From: Simon Davis
Sent: 21 May 2019 10:39
To: Planning Scanning
Subject: FW: GTR DENMANS LANE FONTWELL AL/27/19/DOC

From: John Carver [REDACTED]
Sent: 21 May 2019 09:14
To: Simon Davis [REDACTED]
Subject: RE: AL/45/18/PL GTR DENMANS LANE FONTWELL

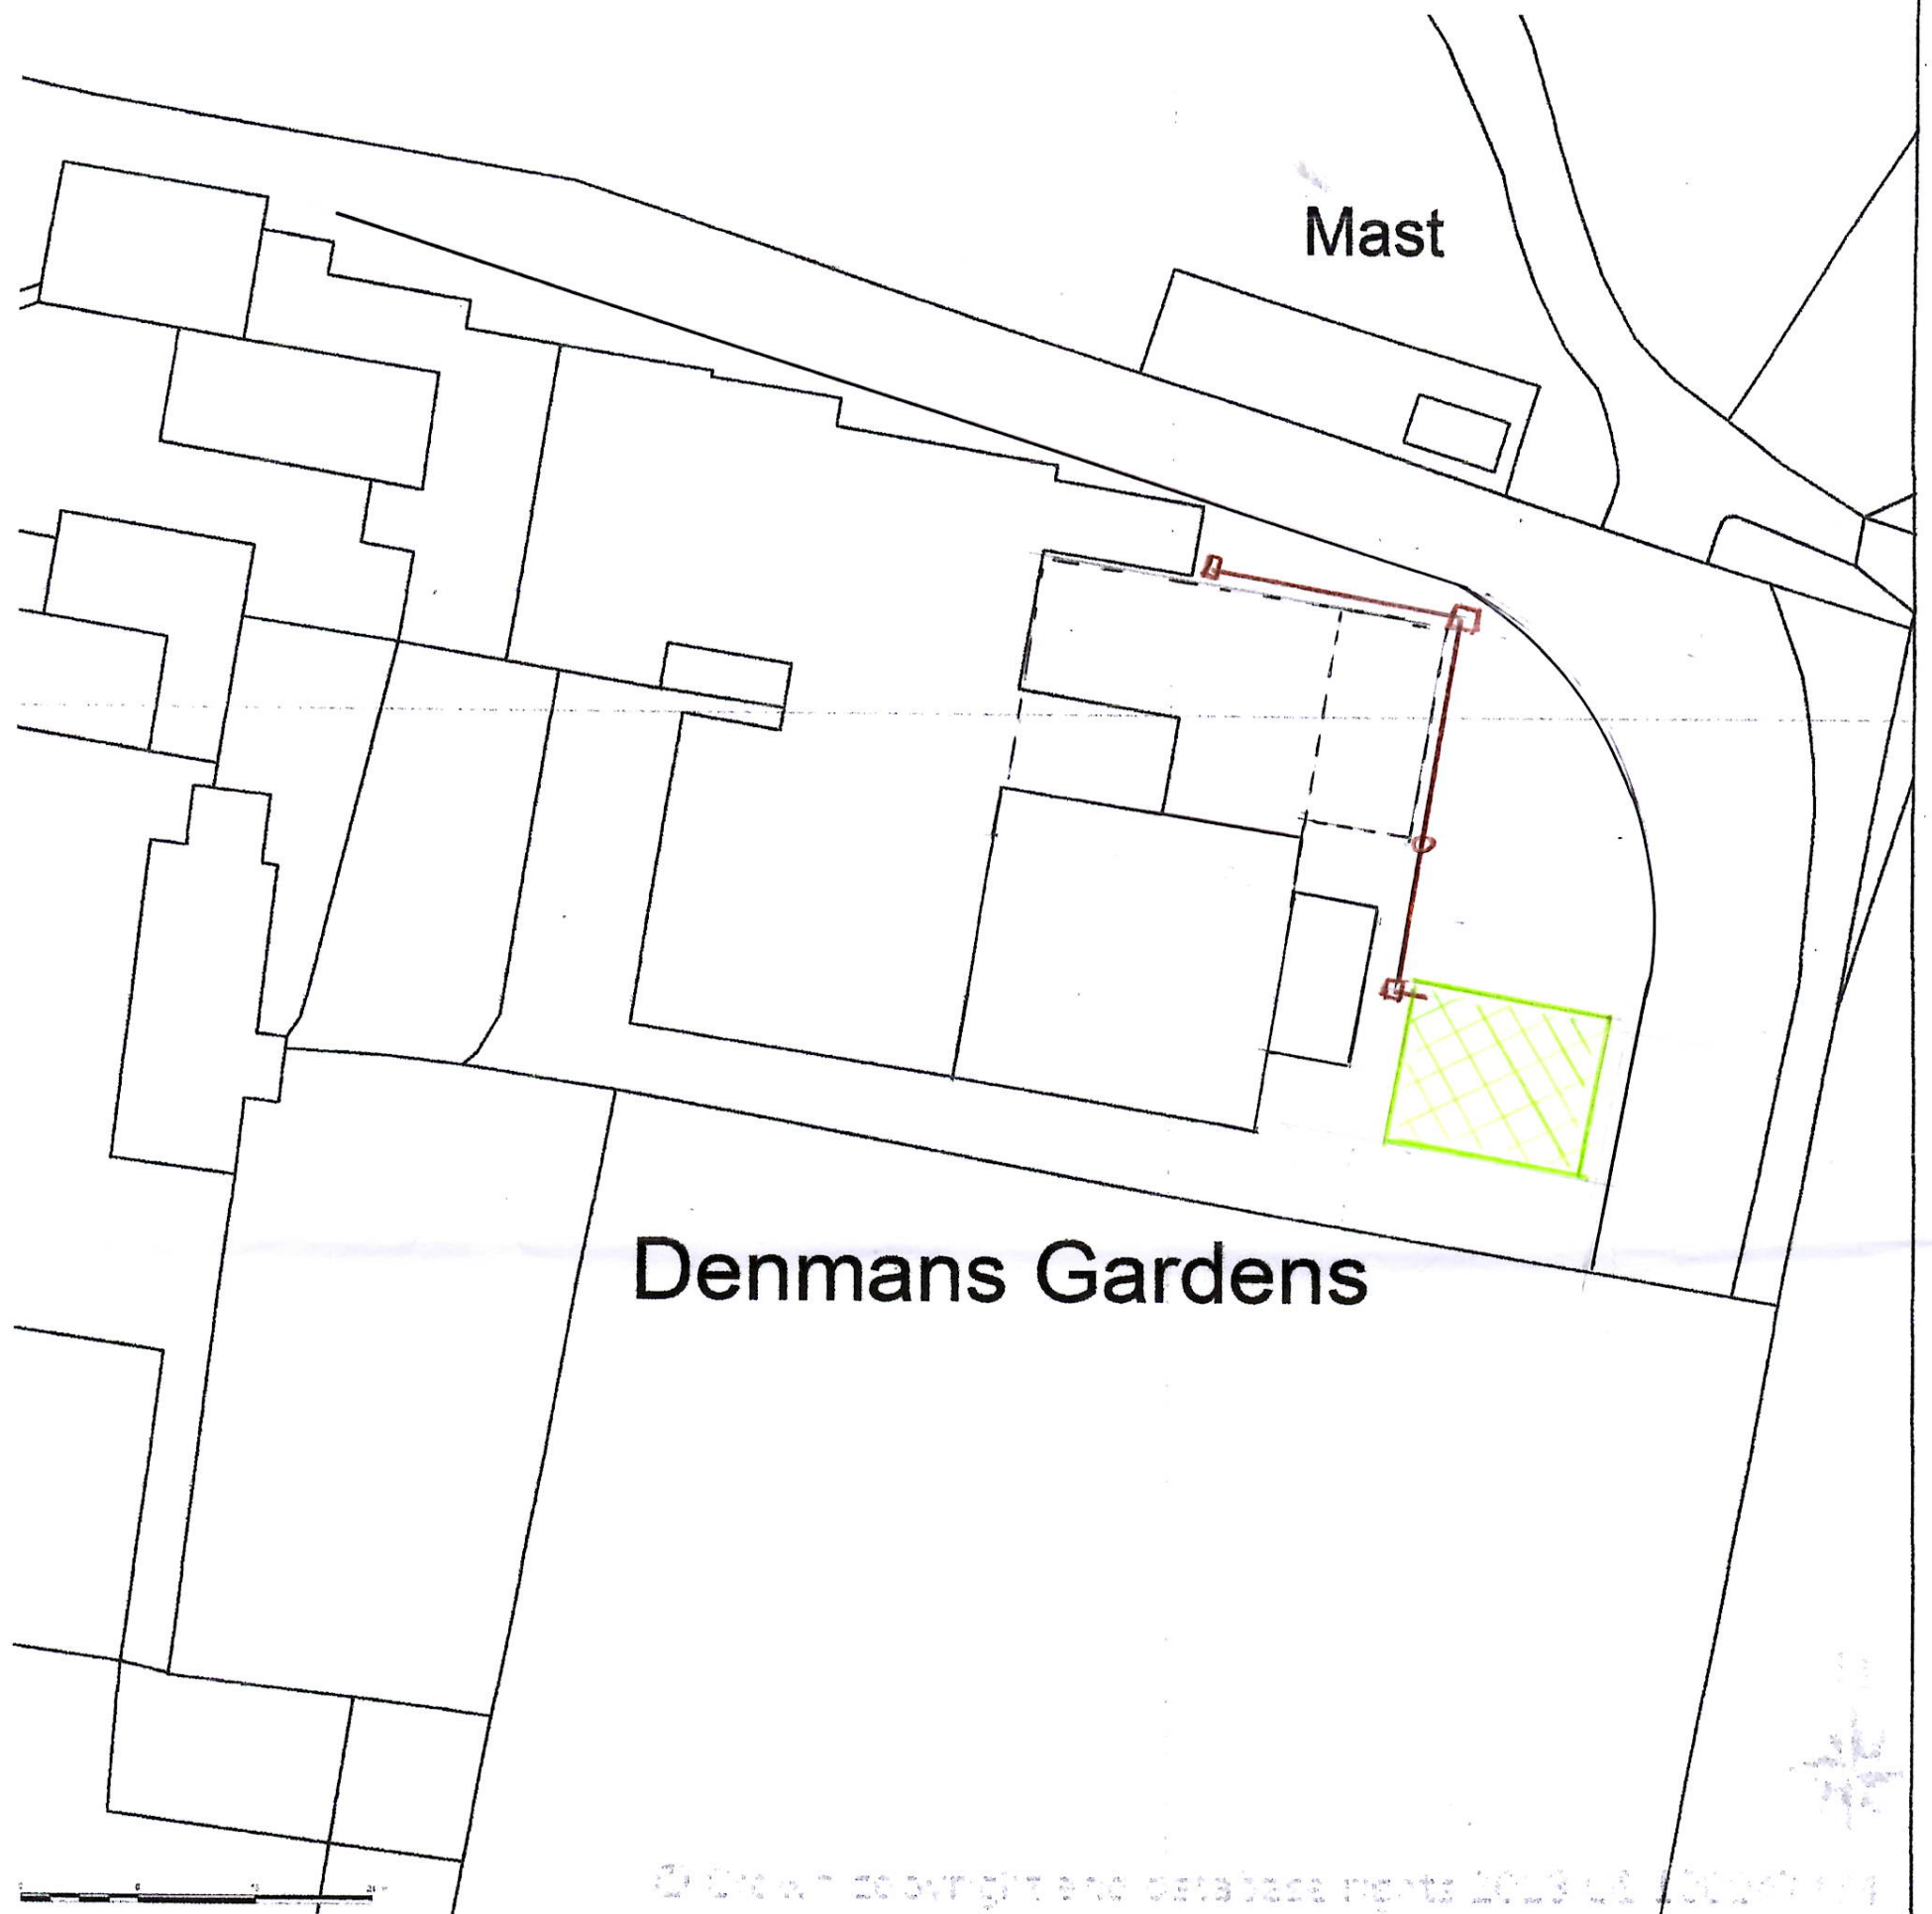
Thanks for these. However, the A3 portrait template block plan does not appear to show anything – can you check please.

FOUNDATION NOTES :-

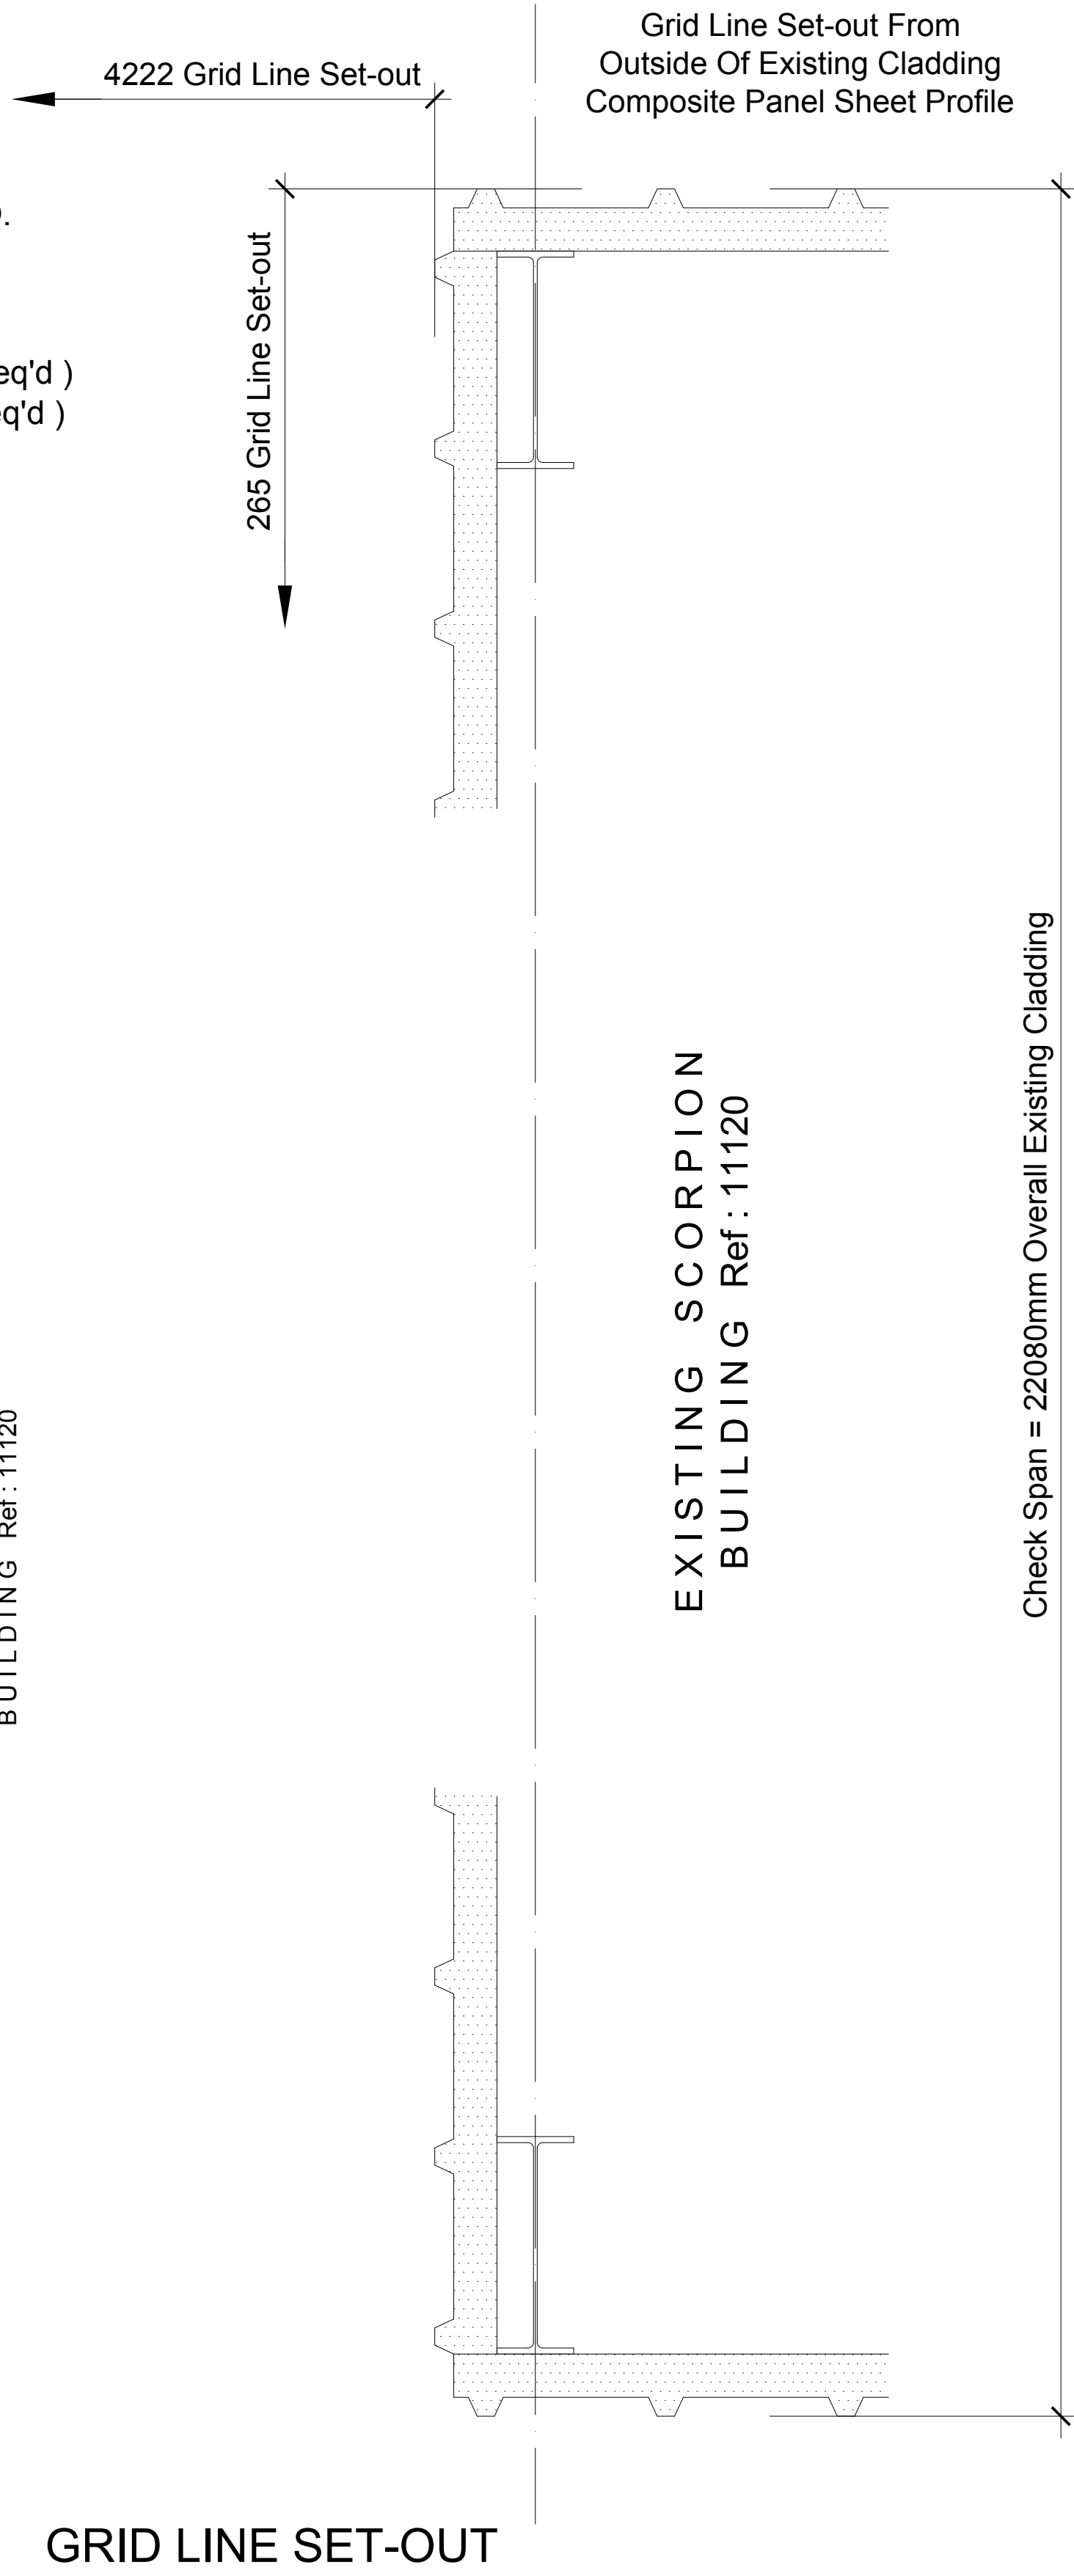
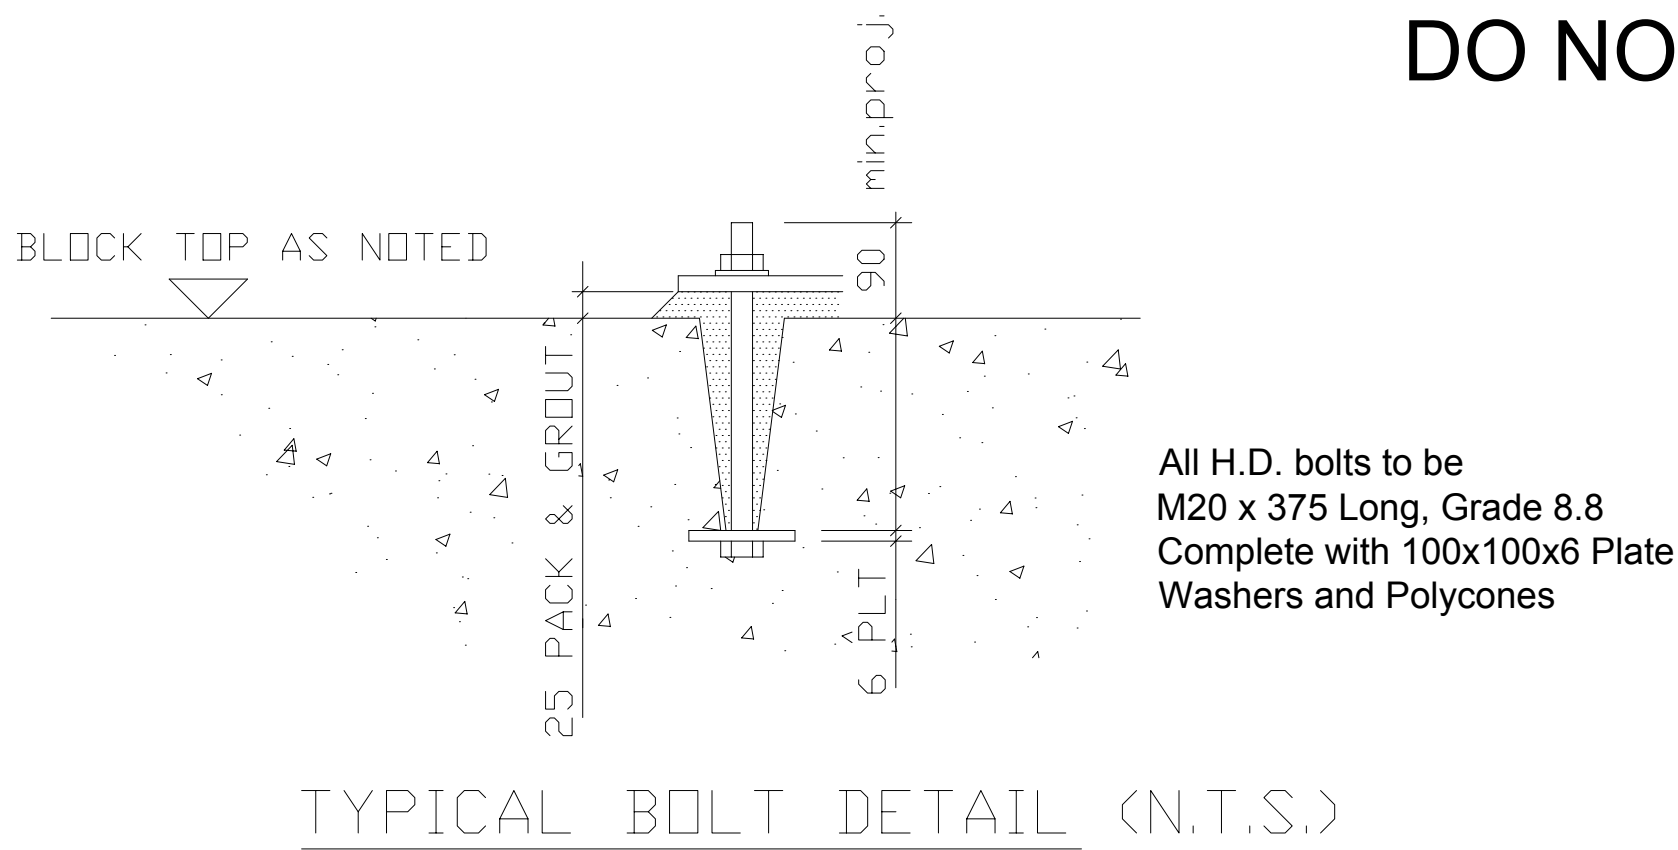
Regarding condition 08, this only requires discharge if you are using piling or other foundation designs using penetrative methods. You state that piling or trenching will not be used but you are proposing a foundation depth of 1.75m. Therefore, do I assume that you are using a penetrative method? We have consulted the EA and I have not yet heard from them so I will chase today.
